WEST SUSSEX COUNTY COUNCIL CONSULTATION

TO:	Arun District Council FAO: Simon Davis
FROM:	WSCC - Highways Authority
DATE:	2 March 2022
LOCATION:	Land adjacent to Sefter School House Sefter Road Bognor Regis PO21 3EE
SUBJECT:	P/15/22/DOC Approval of details reserved by condition imposed under ref P/116/19/OUT relating to Condition Nos 9 - surface water drainage, 10 - discharge flows to watercourses, 11 - maintenance & management of surface water drainage, 12 - foul drainage assessment, 13 - contamination, 14 - Construction Management Plan and 15 - Arboricultural Impact Assessment.
DATE OF SITE VISIT:	n/a
RECOMMENDATION:	Advice
S106 CONTRIBUTION TOTAL:	n/a

Condition 14 - Construction Management Plan

Title : Construction Management Plan

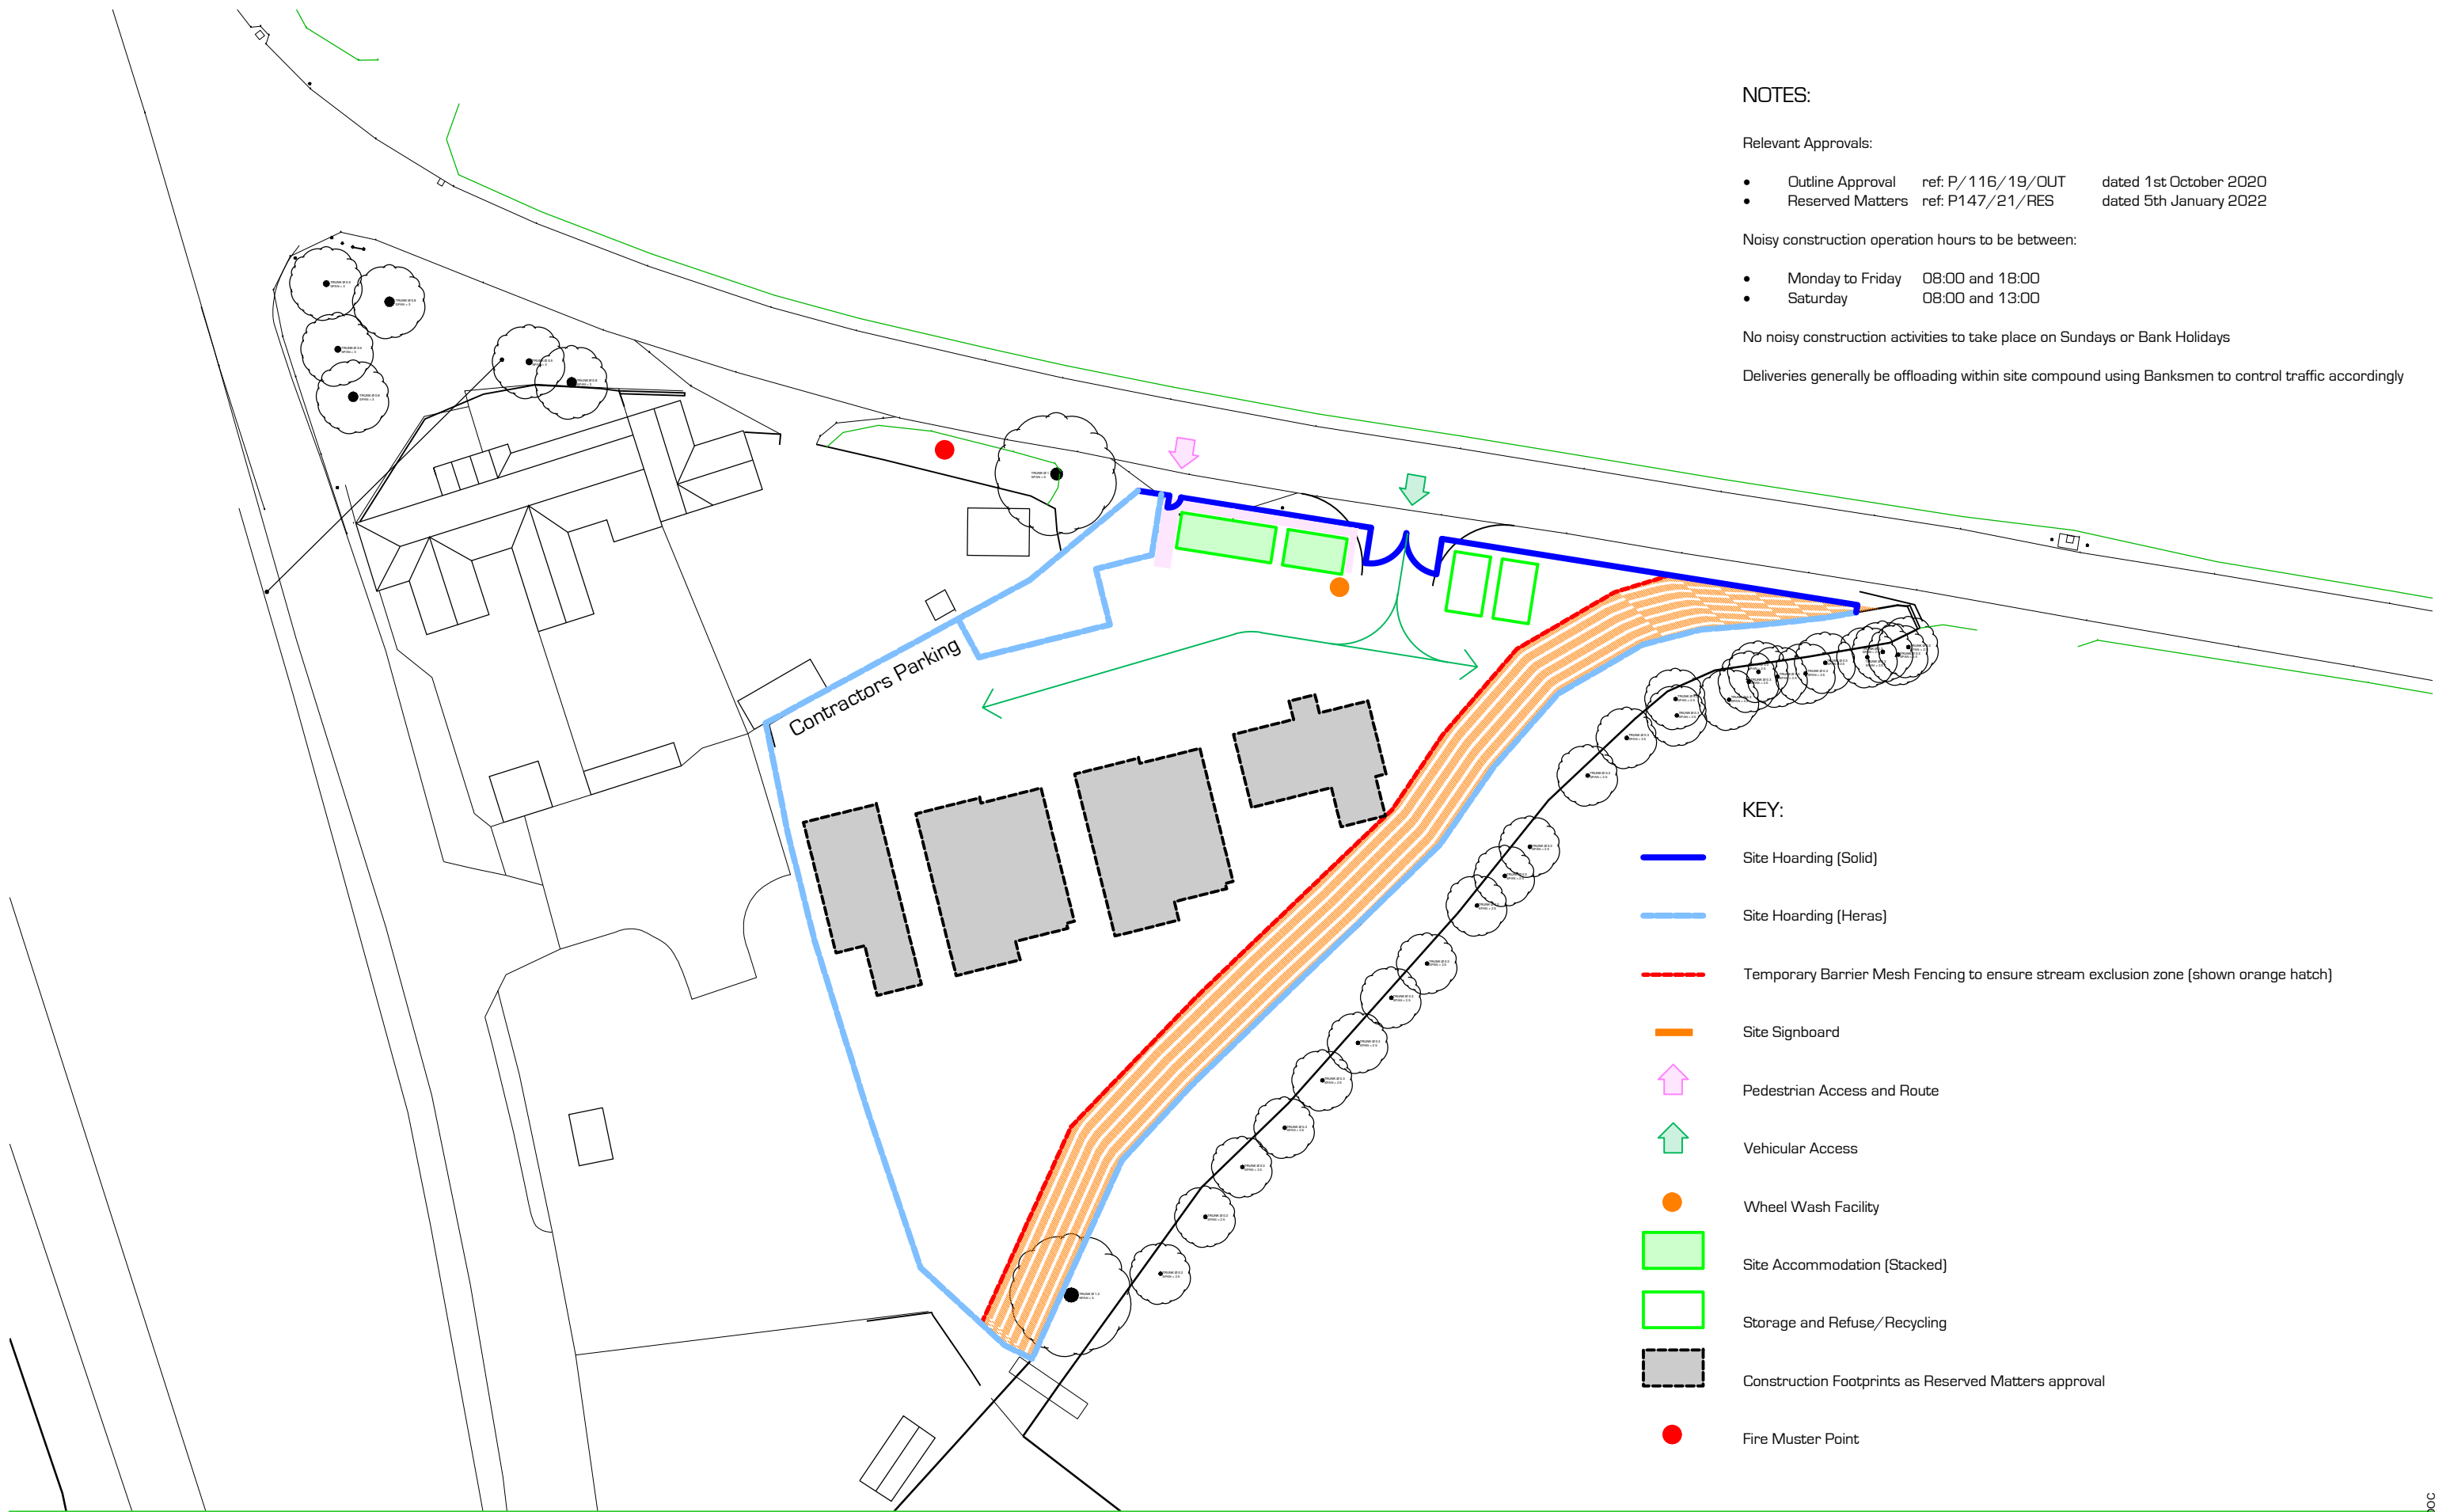
A plan has been submitted which appears to cover the highways aspects of the above condition, demonstrating the location of parking for contractors vehicles within the site boundary. loading

and unloading will be within the site compound and banksmen will be available to control traffic. Plant, materials and waste will be stored on site within the site boundary and will not be stored within the public highway. Security hoarding will be erected to the site boundaries to prevent unauthorised access. Wheel washing facilities will be located on site, within the boundary. The LHA is satisfied with the details provided from a highway safety aspect, but acknowledges that other non-highways aspects of the condition have not been covered within the provided Construction Management Plan - as such the LPA may wish to ensure that these matters are dealt with prior to discharging the condition.

As above, the LHA is satisfied with the details provided from a highway safety aspect for Condition 14, however, the LPA may wish to request details pertaining to the non-highways matters of this condition prior to discharging the condition.
